**Table of Response to Submissions SSD 6864 – Sumatran Tiger Adventure, Taronga Zoo**

lahznimmo architects Suite 404, Flourmill Studios 3 Gladstone St Newtown NSW 2042 Australia T 02 9550 5200 F 02 9550 5233 www.lahznimmo.com	DRAWN HC	PLLOT DATE 13/05/2015	SCALE @A1 1:100	
													CHECKED AN	PROJECT NO. 14/07	DRAWING NO. A - D A - 1 0 1	REV. NO 01

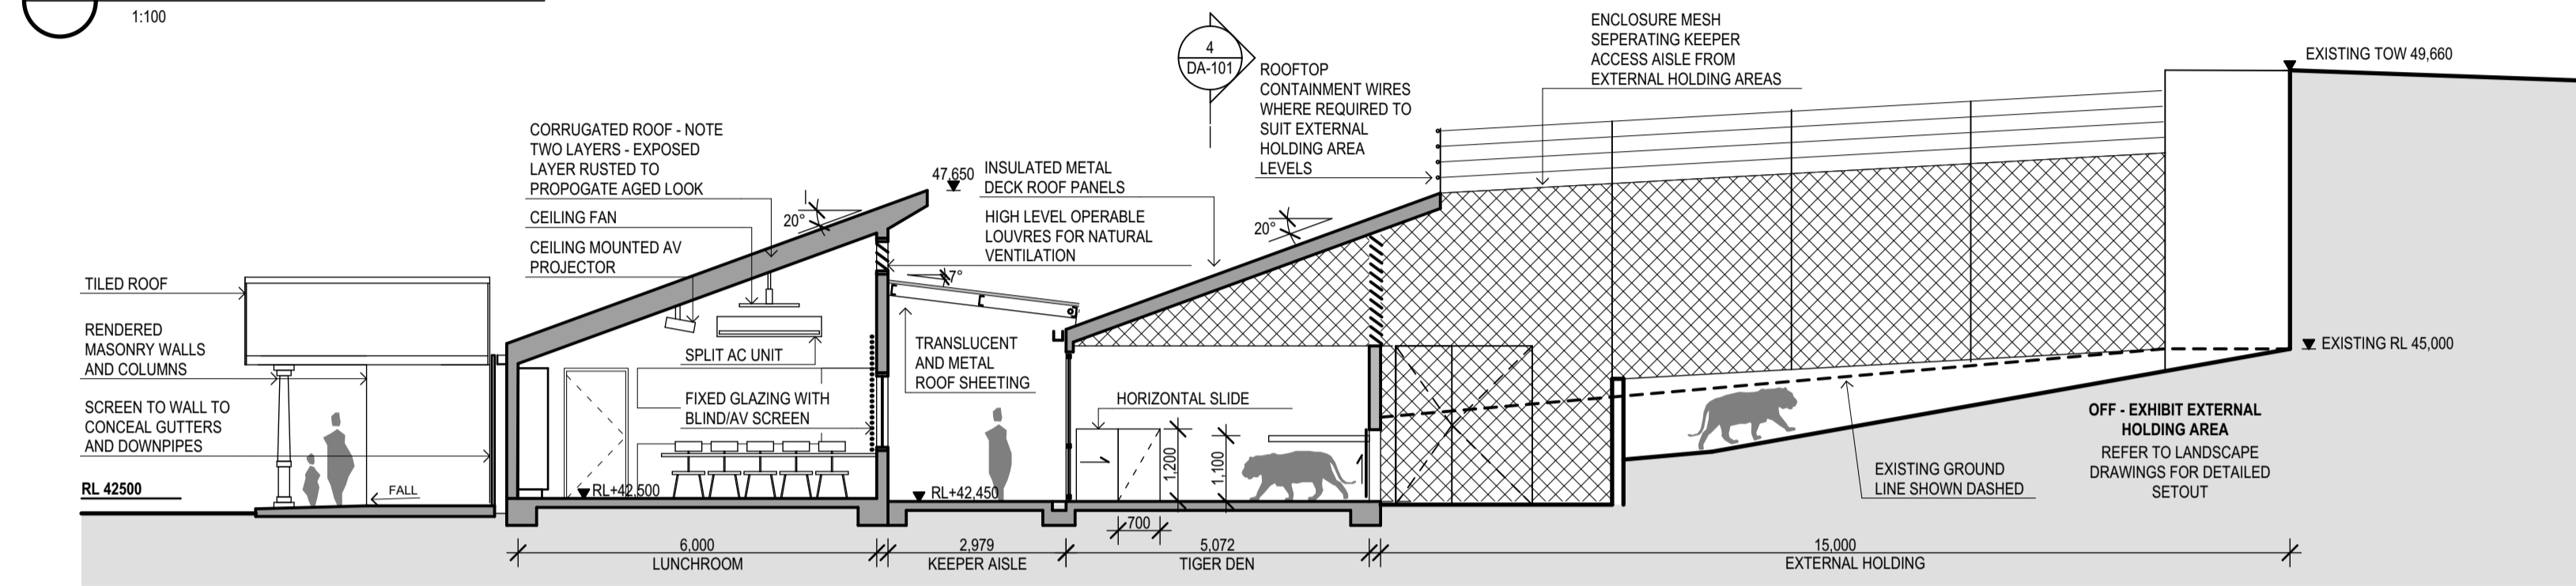
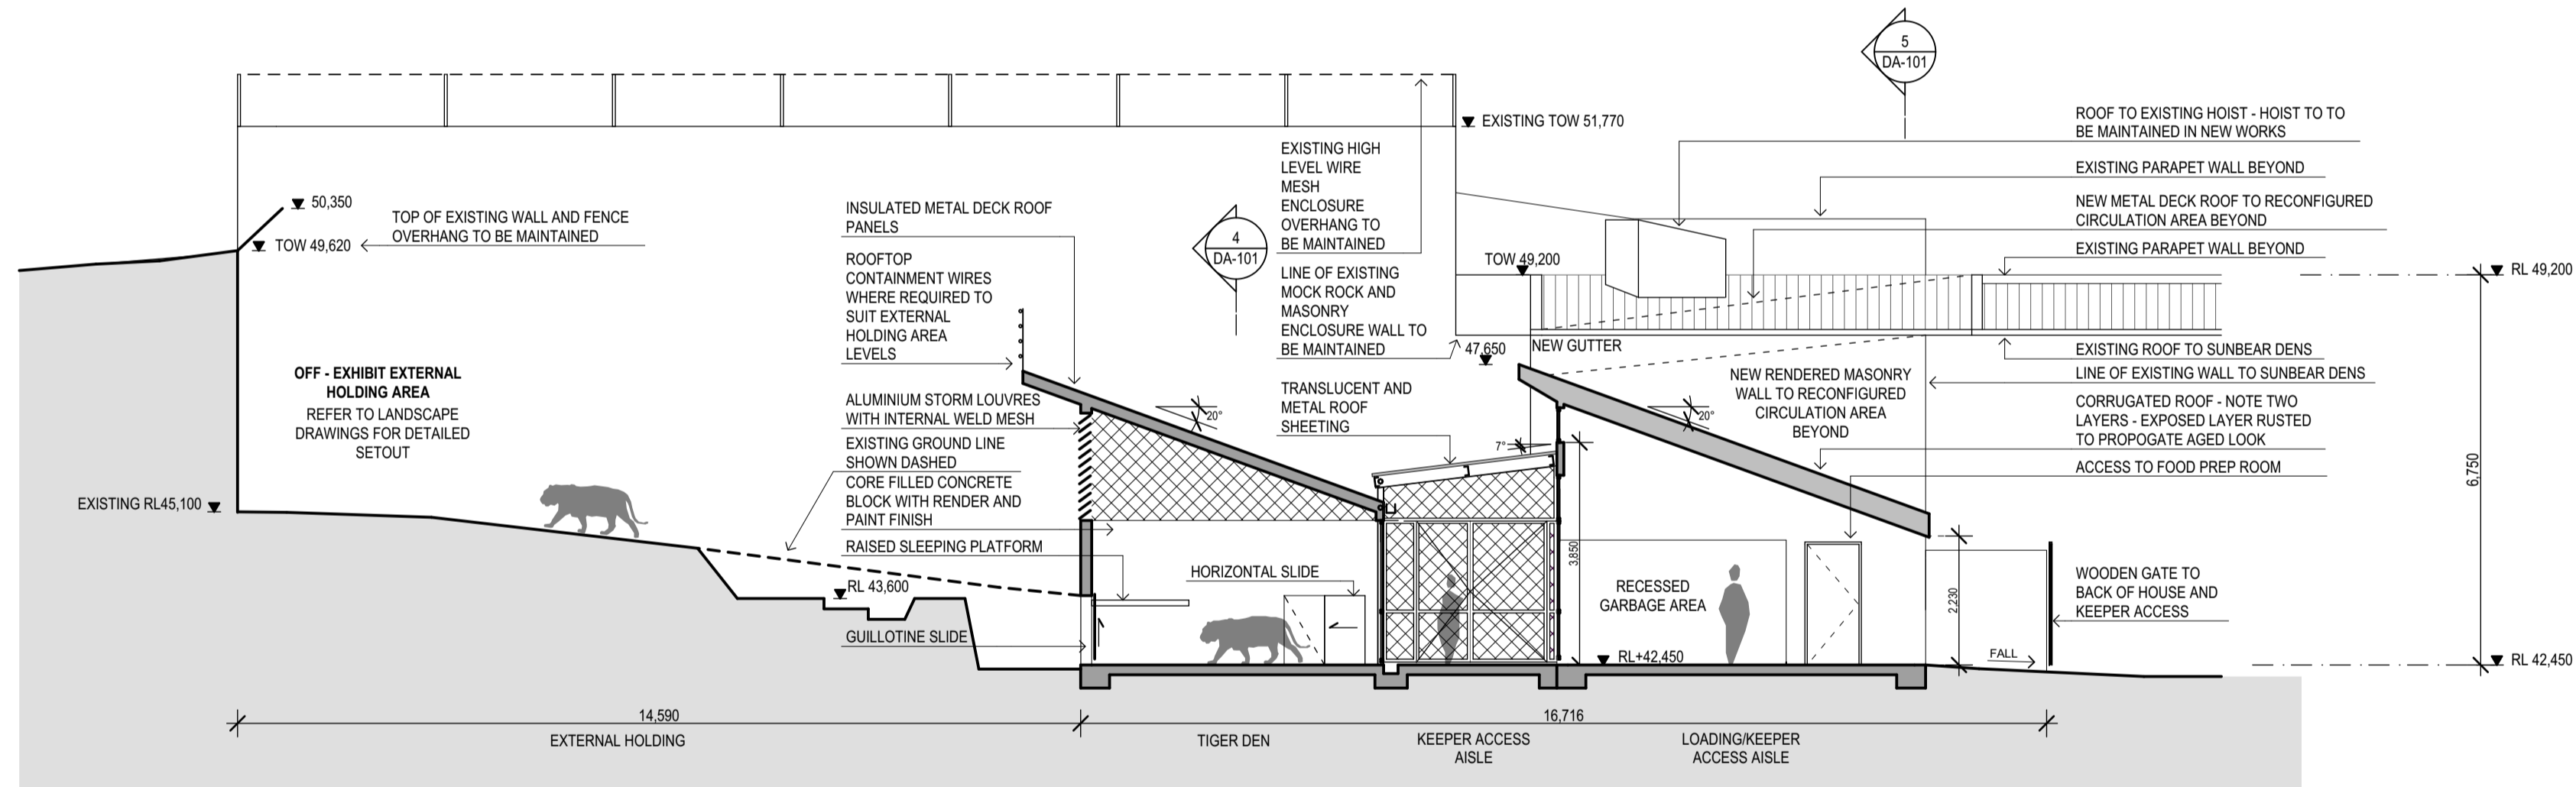
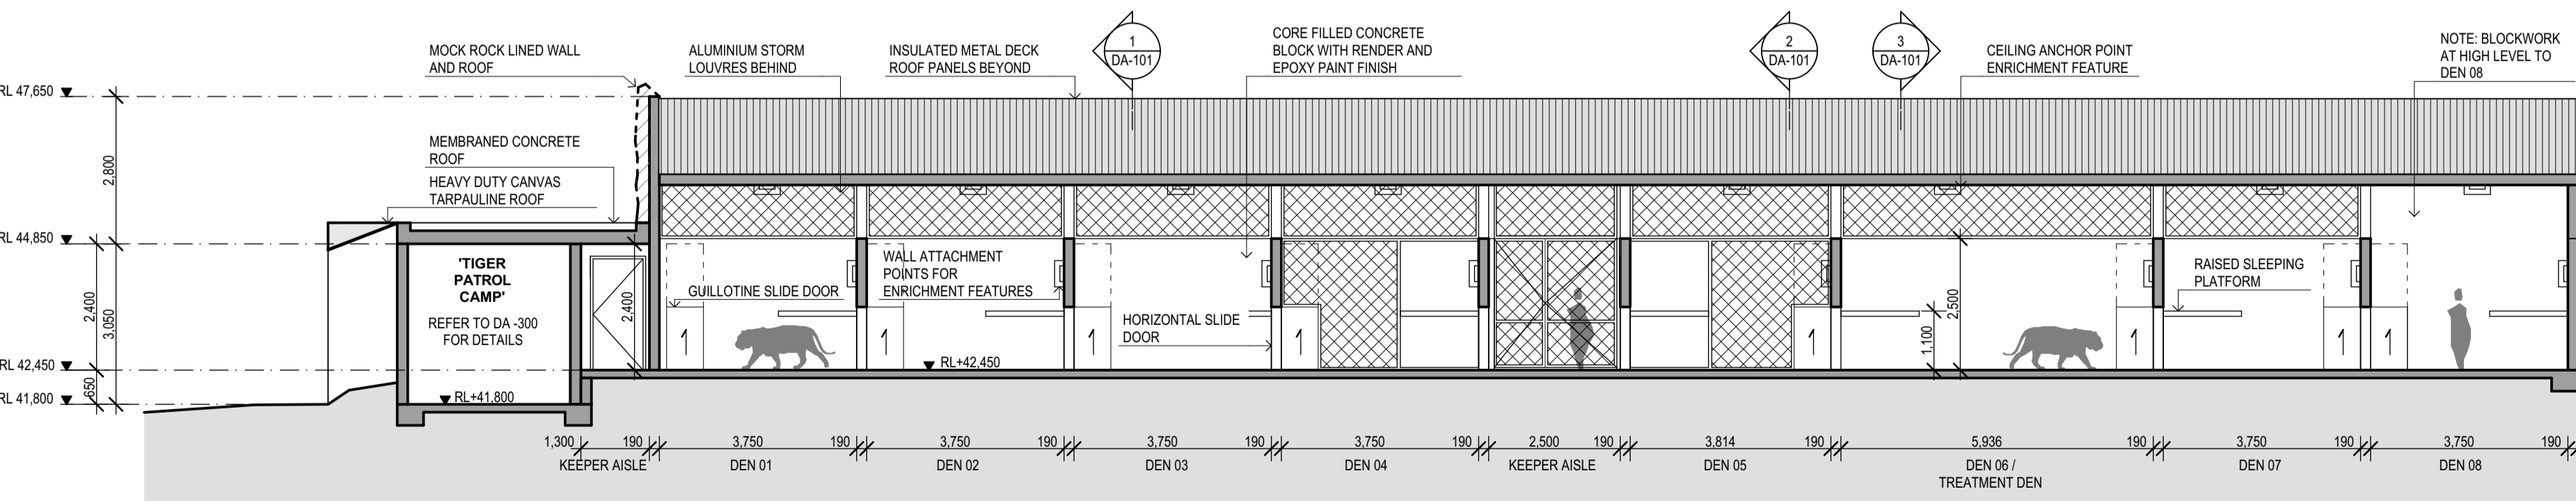
accordance with existing practices including the direction of run off and waste water from the exhibit to the existing water recycling plant which has an existing environment protection licence.	
Fire & Rescue NSW	
No comments.	Noted. No further response required.
Foreshores and Waterways Planning and Development Advisory Committee of the Department of Planning and & Environment	
The redevelopment of the exhibit will remain in keeping with the overall character and appearance of the zoo when viewed from the harbour. As such, the Committee does not have any specific comments.	Noted. No further response required.
NSW Office of Environment & Heritage	
<p>Aboriginal cultural heritage</p> <p>The EIS does not identify whether additional water management other than the removal of existing structures and paths is necessary and if so what is proposed.</p> <p>Further advice should be provided as to whether additional water re-direction is necessary and required to address current water movement over and through the rock shelter is required.</p> <p>OEH recommends that these details should be clearly incorporated into the plans and EIS documentation and provided to DPE prior to determination of the SSD. Note that further referral to OEH is not required if DPE is satisfied that this matter has been appropriately addressed.</p>	<p>A new concrete spoon drainage line is proposed to sit between the existing path and new wall mesh enclosure line of proposed exhibit 3 to accommodate and redirect water from the rock shelter to a new stormwater pit which will form part of the broader hydraulic plans for the site.</p> <p>This is illustrated in updated the Hydraulic Stormwater Plan and Section drawings A – DA- 20.</p>
